WILKINS ENGINEERING, P.C.

January 26, 2021

REFERENCE: Metal Building Construction
129 Kipling Road
Fuquay Varina, N.C.

I have reviewed the design drawing provided by you for the rigid frame metal frame building to be constructed at the above referenced location. My findings and recommendations are outlined below.

DESCRIPTION: COVER SHEET
SIZE: SEE BUILDING DESCRIPTION ABOVE
CUSTOMER: CAROLINA METAL STRUCTURES
LOCATION: ANCIEN, NC
JOB NO.: 0605-199945
SHEET NO.: C1 of 1

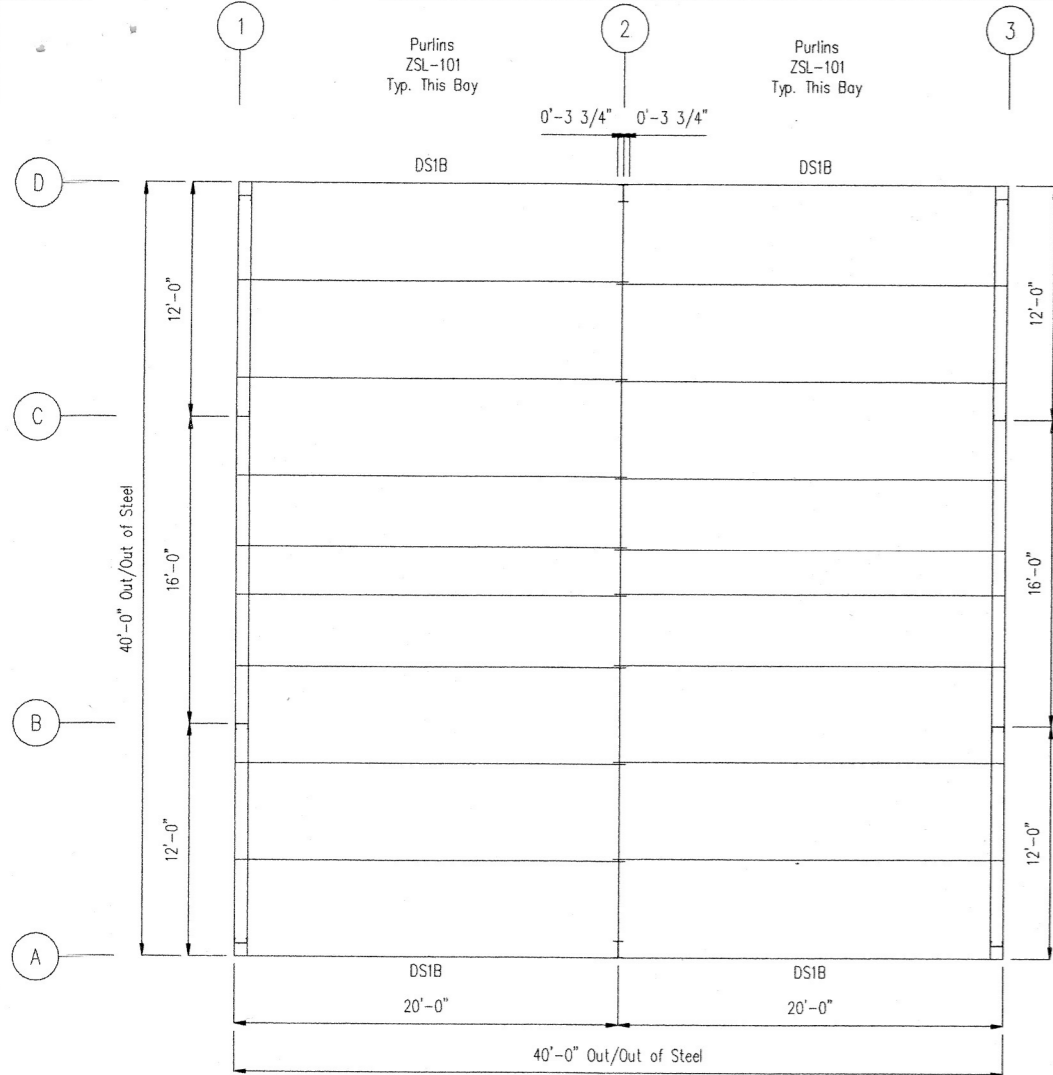
The structural design for this building was provided by Metallic Building Company of Houston, Texas for Carolina Metal Structures. The design drawings (project 0605-199945) were issued for construction March 18, 2002. The design parameters given on the design drawings show a wind design velocity of 80 MPH. The result of increasing the design wind velocity on a rigid frame structure is that horizontal and vertical reactions at the base of the structure are increased proportionally. Rigid frame base reactions for a structure of the size shown on the design drawings would be on the order of 8 kips horizontal and 12 kips vertical at each rigid frame depending on the direction of the wind load. This is a "worst case" load evaluation and these loads are not realized at the end wall frames. I have checked the anchor bolt and base plate design shown on the design drawings and find them structurally adequate to carry the aforementioned loads. These loads should be used to determine the size of footings at the base plate locations. In discussions with a manufacturer who produces the same rigid frame structures I was advised that this structure will meet increased design wind velocity of 115 MPH requirement in the 2018 Code. Accordingly, this pre-manufactured structure can be constructed at your location without any upgrade or addition to the rigid frame.
